Response to Planning Application

From: Arun District Council Greenspace

Application ref: LU/116/21/PL - Revision

Description: Erection of 112 No. residential units with access from Fitzalan Road, open space, hard and soft landscaping works, internal roads/footways, car and cycle parking, substation, bin store and associated engineering and infrastructure works. This site is in CIL Zone 4 (Zero Rated).

For Softworks key refer to
LTH-NTA-XX-00-DR-L-0505/0506

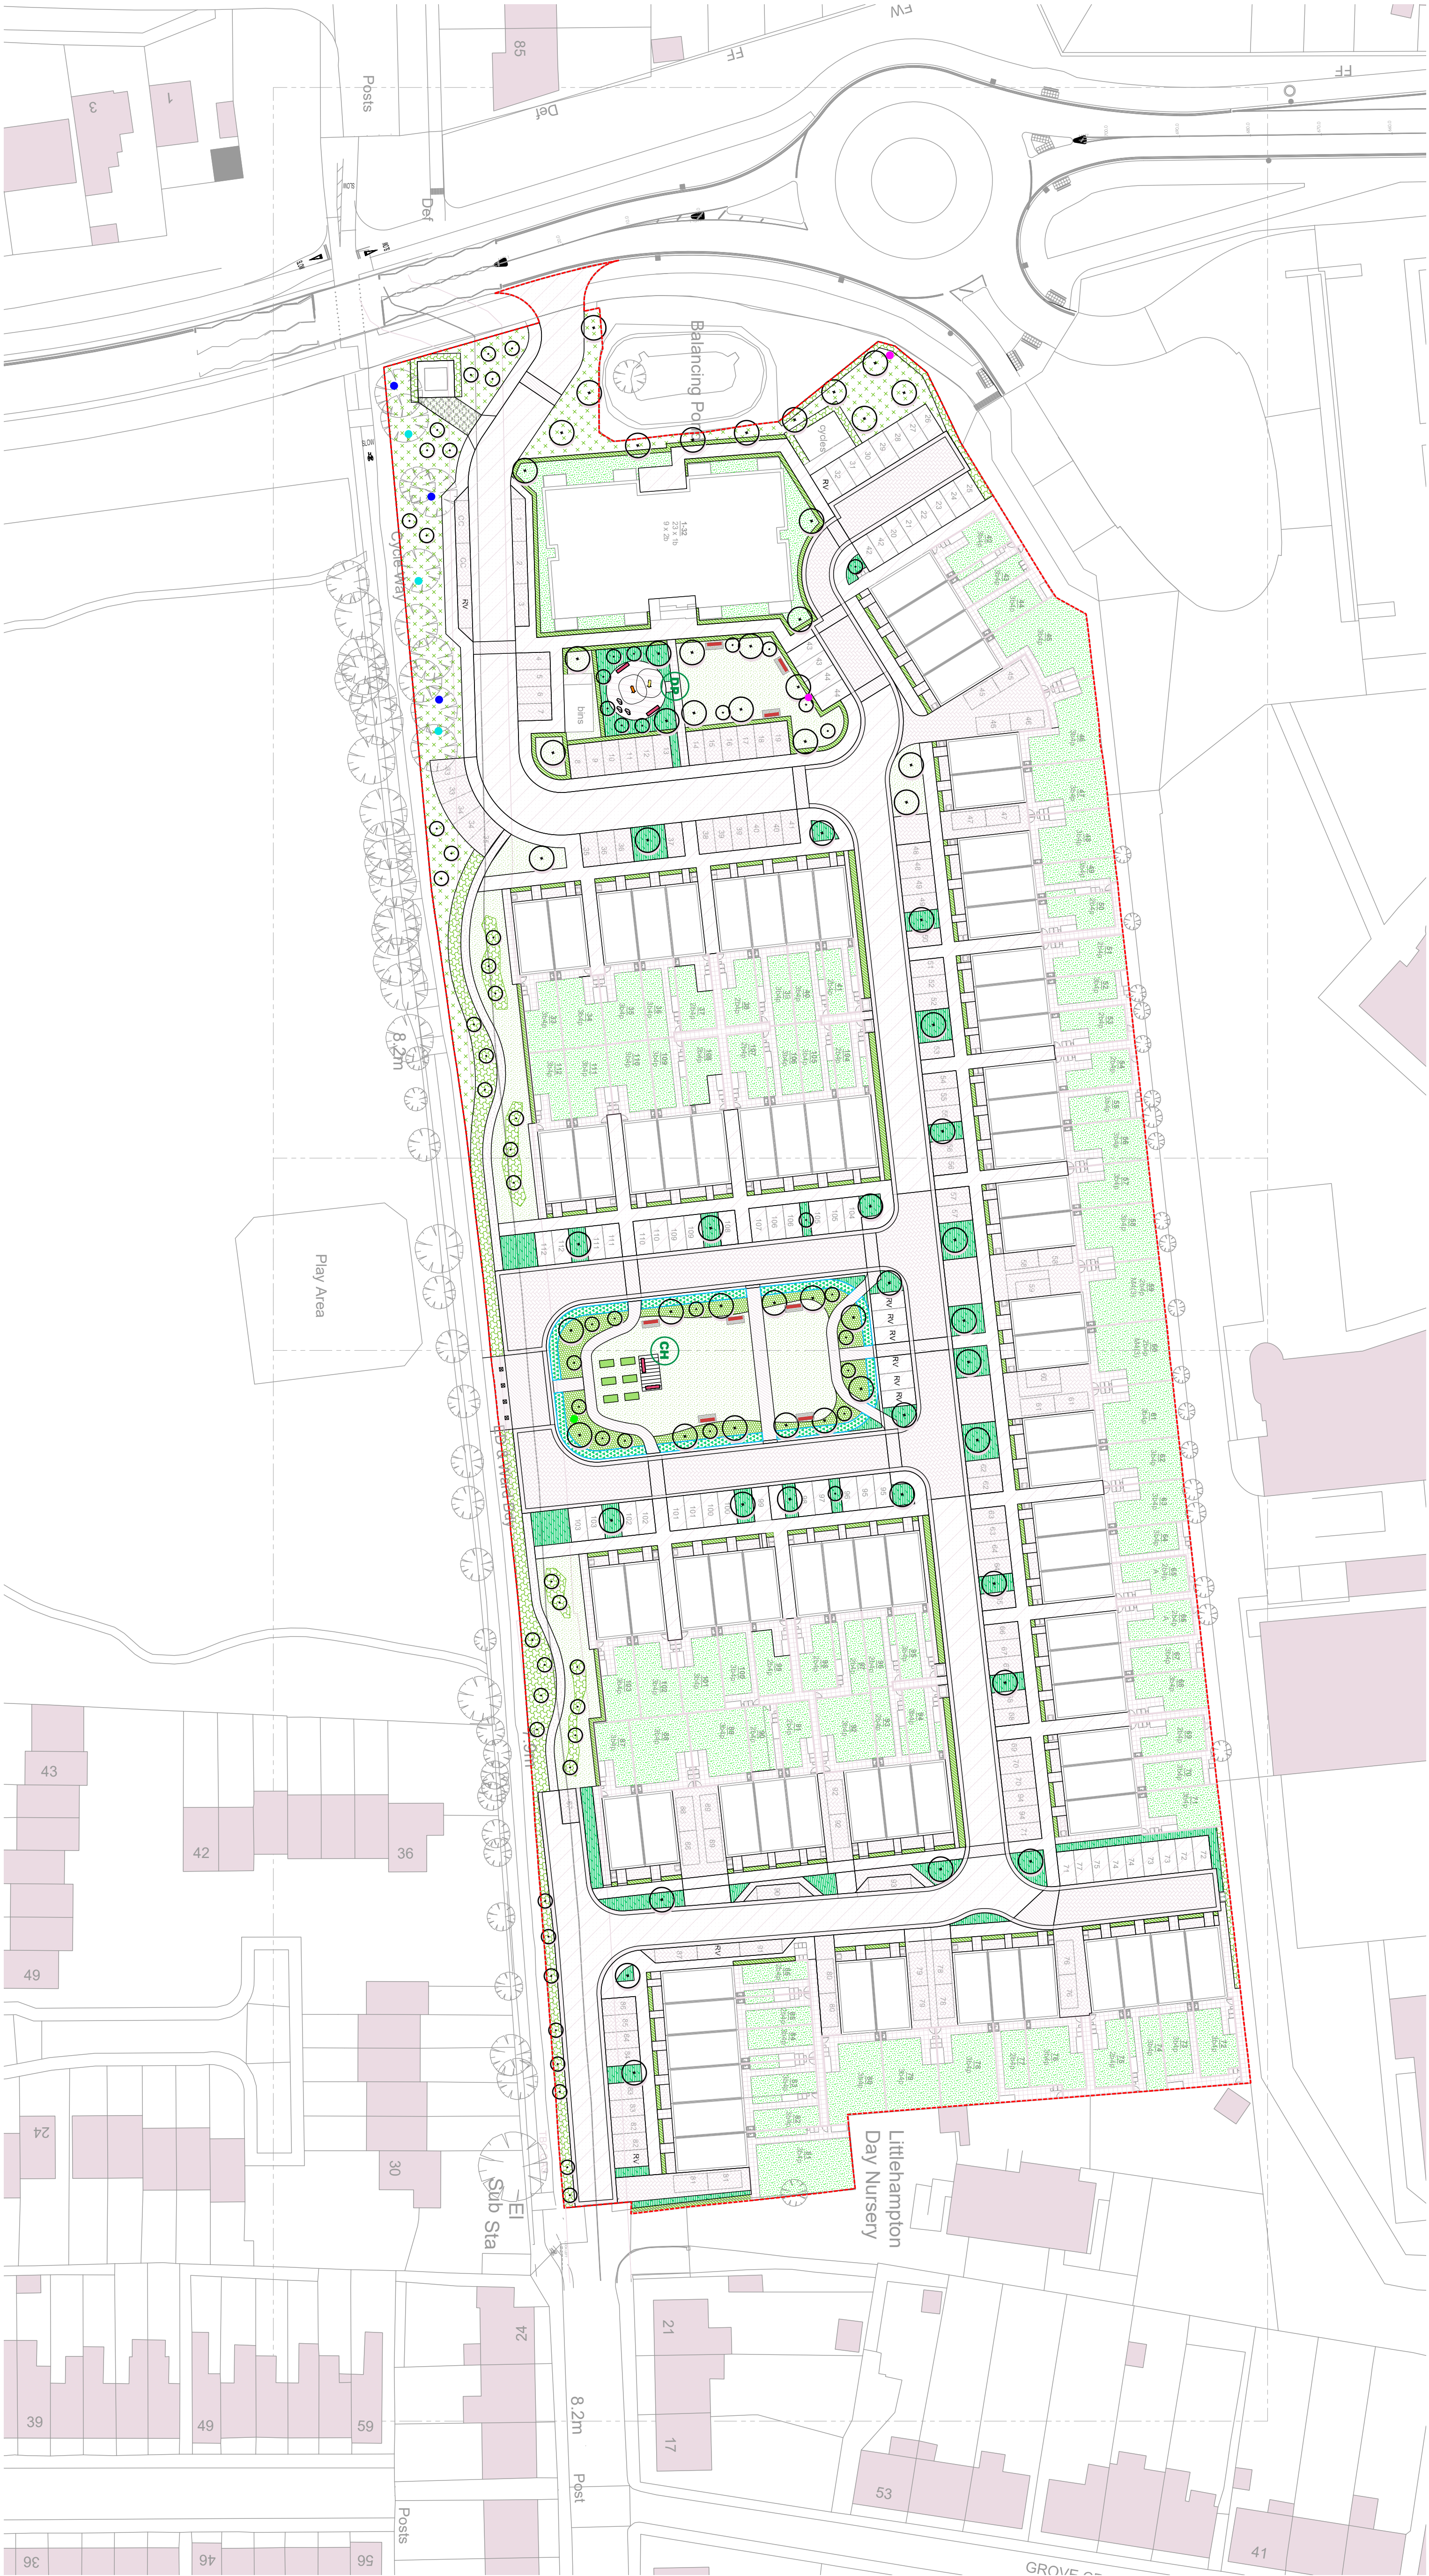
The detail under LU/55/15/OUT (68 dwellings) included a Public open space area centrally located within the development. The proposals under this REVISED application LU/116/21/PL now revised under substitute drawings Landscape Masterplan LTH-NTA-XX-00-DR-L-0501 Rev P04 Landscape GA softworks Sheets 1 of 2 LTH-NTA-XX-00-DR-L-0504 Rev P04 and Landscape GA softworks Sheets 2 of 2 LTH-NTA-XX-00-DR-L-0505 Rev P04 show a central POS area which is now allocated as POS with the children's play omitted in favour of 106 contribution which would be preferable. In addition also have been indicated within the 106 agreement offsite financial contributions for playing pitches/3G pools/ halls and ancillary facilities as outlined in ADC SPD Open Space, Playing Pitches, Indoor and Built Sports Facilities January 2020.

It had previously been recommended for play that a preference for offsite provision with a financial contribution for offsite provision made. It would be advised that play would be better situated as an offsite contribution and as agreed in the previous 106 application rather than located on this site. The previously drafted 106 agreement recognised the requirement for children's play and 106 monies were agreed for offsite improvements to Rosemead Park play area immediately to the south which is a Parish owned facility.

SuDS provision appears to have been shown now to the rear of the apartment block area (removed from the apartment block frontage which is preferable) the full implication of SuDS including future management and maintenance must be considered, also the proximity to these residential dwellings. The recommendation that these are subject to RoSPA or similar organisation inspection should be noted. Detail to be provided as to whether these are likely to be wet or dry areas; this has implications where situated near to residents and play areas. Where they are to remain wet for long periods their safety must be assessed regarding the proximity to residential areas. Any such SUDS features should be designed as beneficial wildlife, amenity and landscape features and incorporated as part of an open space or landscaping scheme for the development.

Pedestrian and cycle routes within the development will need to provide purposeful links for connectivity beyond the development site. Pedestrian and cycle links to Fitzalan Road, Elm Grove Road and the POS to the south of the site need to be ensured.

Recommend landscape approval of the relocating of the children's play via Section 106 contributions into the adjacent Rosemead play area for improvement and therefore allowing the shown central POS area now available as suitable POS (considering also the adjacent greenspace) for the whole development.
